Rezoning Transportation Analysis
Petition Number: Insert Zoning Petition #2021-241
General Location Identifier: 10537220

Revision Log:

Date	Description
03-21-2022	First Review (AO)
04-19-2022	Second Review (AO)

Transportation Summary

REZONING SKETCH PLAN
2021-241
 FOR
EAST WT HARRIS
APARTMENTS
 2135 E WT HARRIS BLVD
 CHARLOTTE
 MECKLENBURG COUNTY
 NORTH CAROLINA

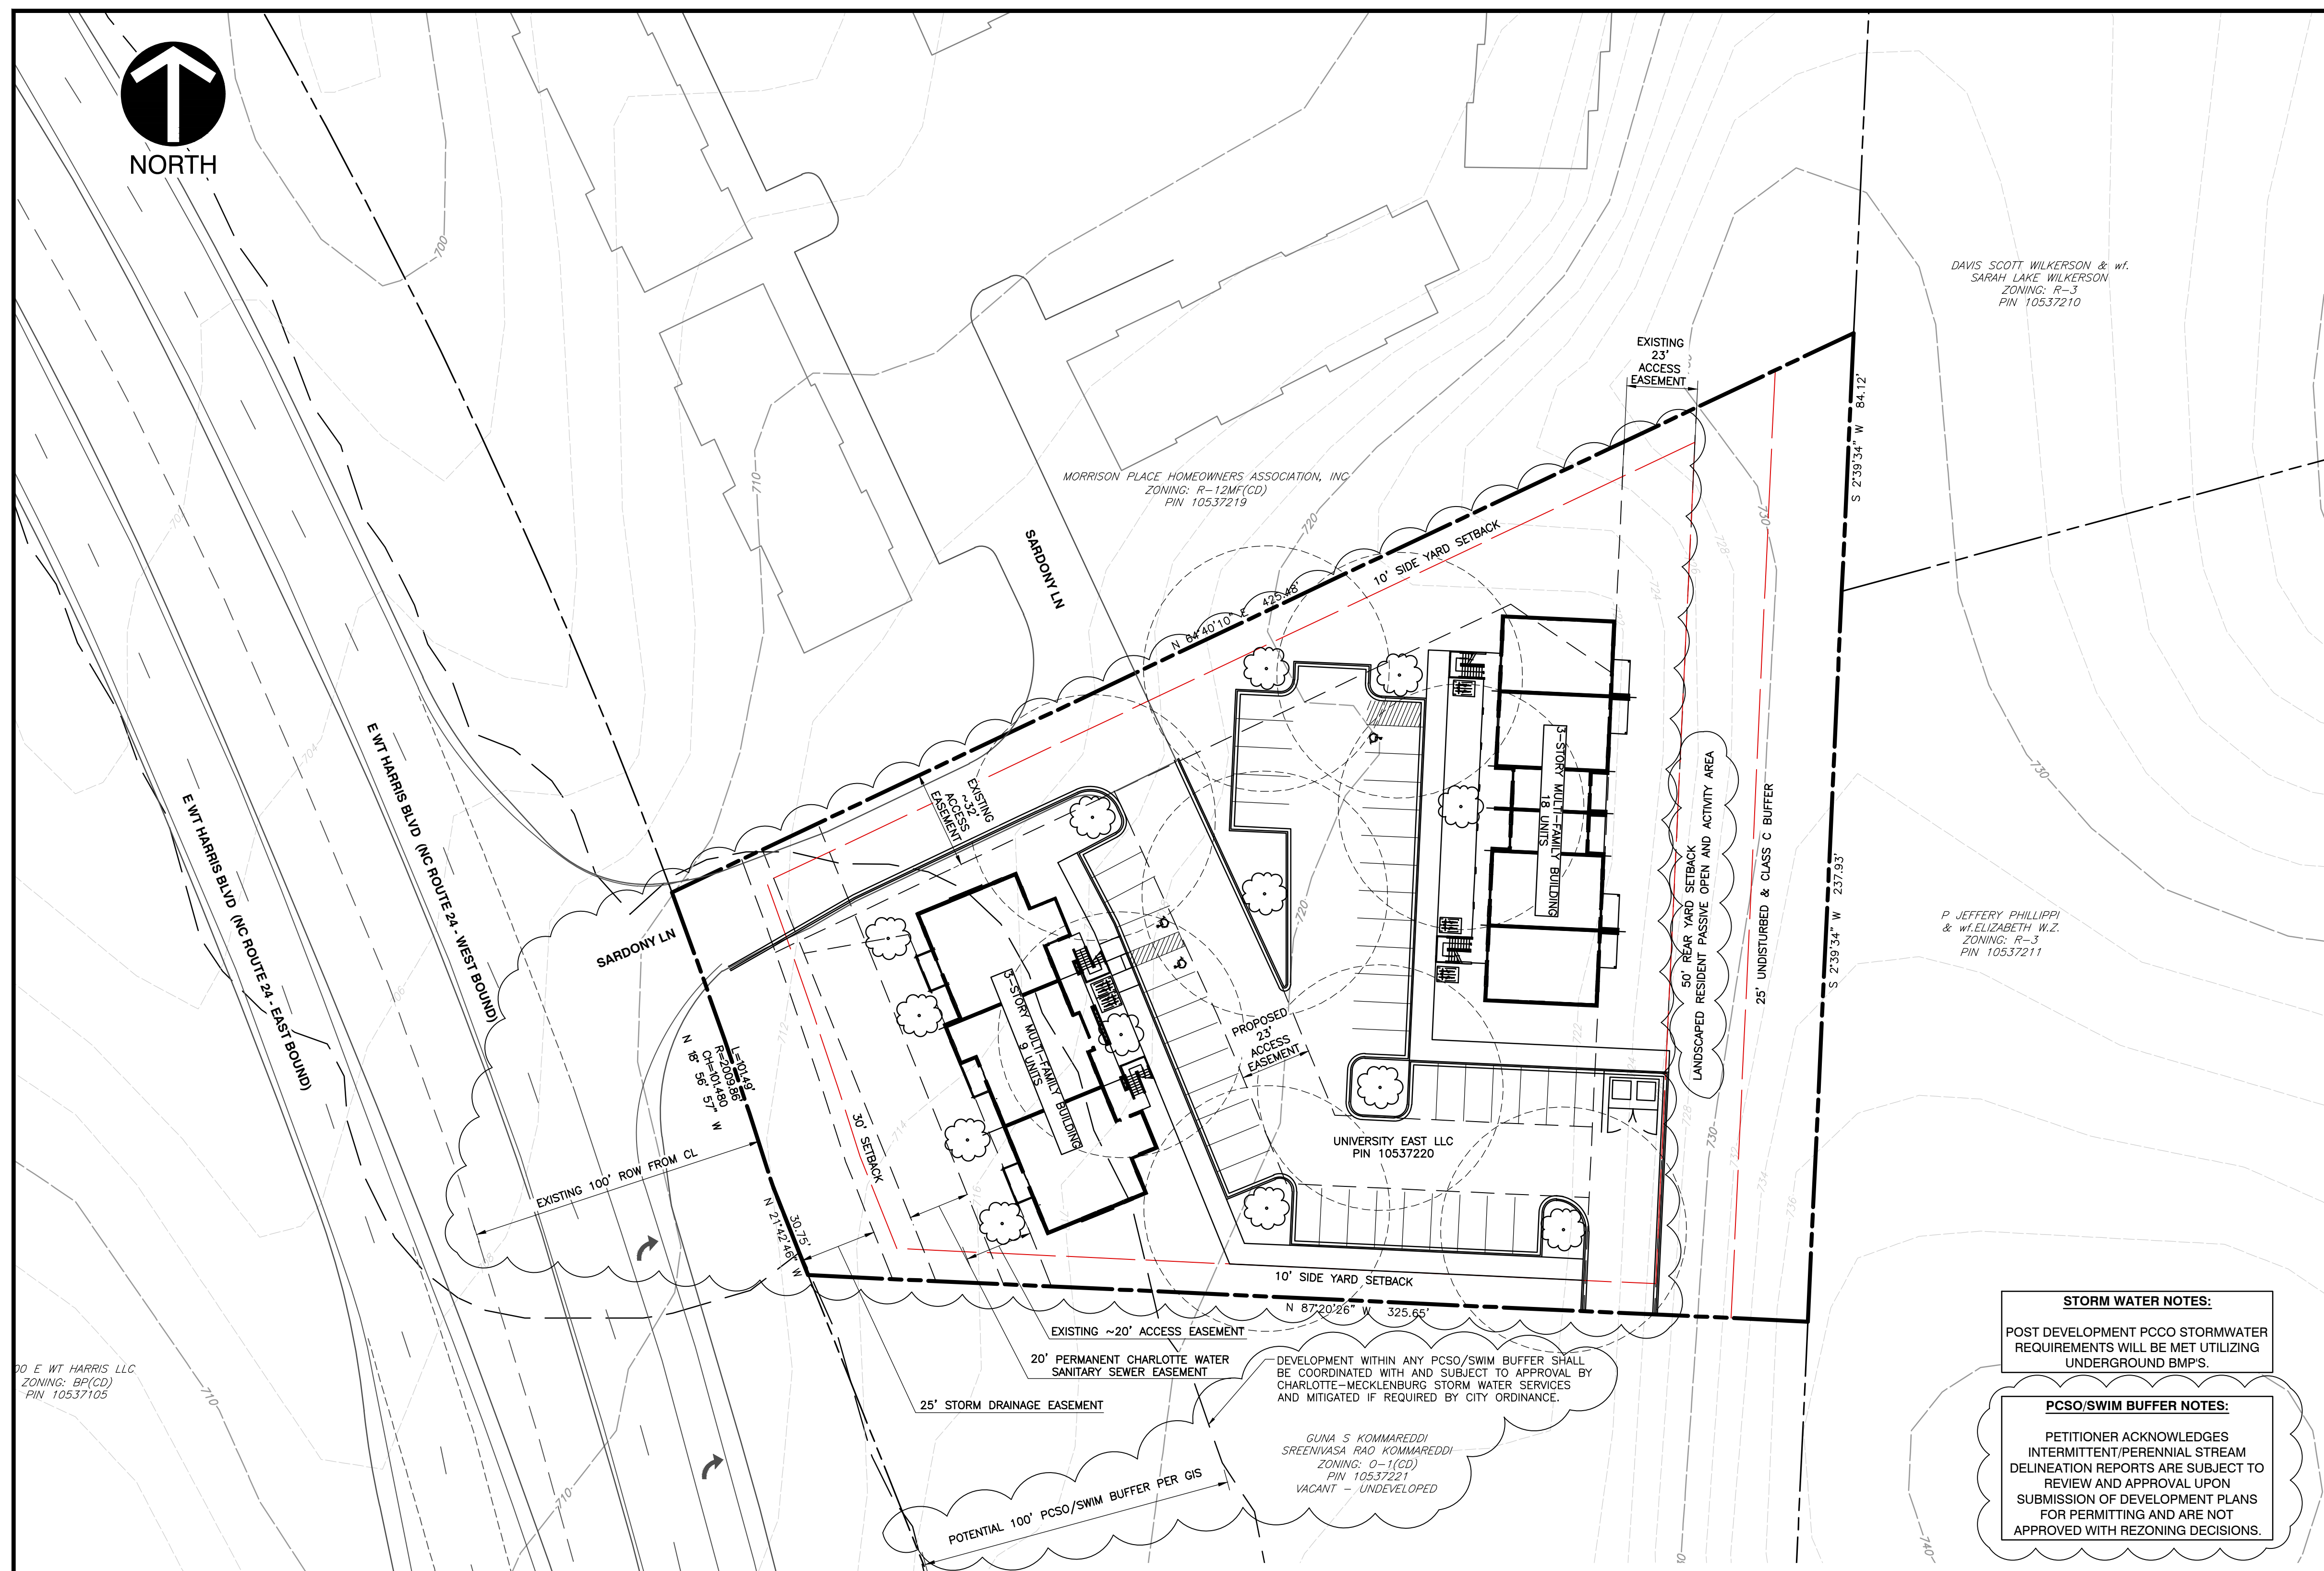
~~2. Revise site plan and conditional note(s) to commit to dedicate 100 feet of right of way from the road centerline of WT Harris Blvd. The site plan shall label and dimension the right of way from the road centerline.~~

~~3. Revise site plan to align proposed driveway aisle with existing Sardony Ln.~~

The site is located on WT Harris Blvd, a State-maintained Class-II major thoroughfare, and Sardony Lane, a private local street. A Traffic Impact Study (TIS) is not needed for this site. The petitioner has committed to dedicating 100' of right of way along WT Harris Blvd, measured from the road centerline and aligning the proposed driveway with existing Sardony Lane. CDOT has no outstanding issues.
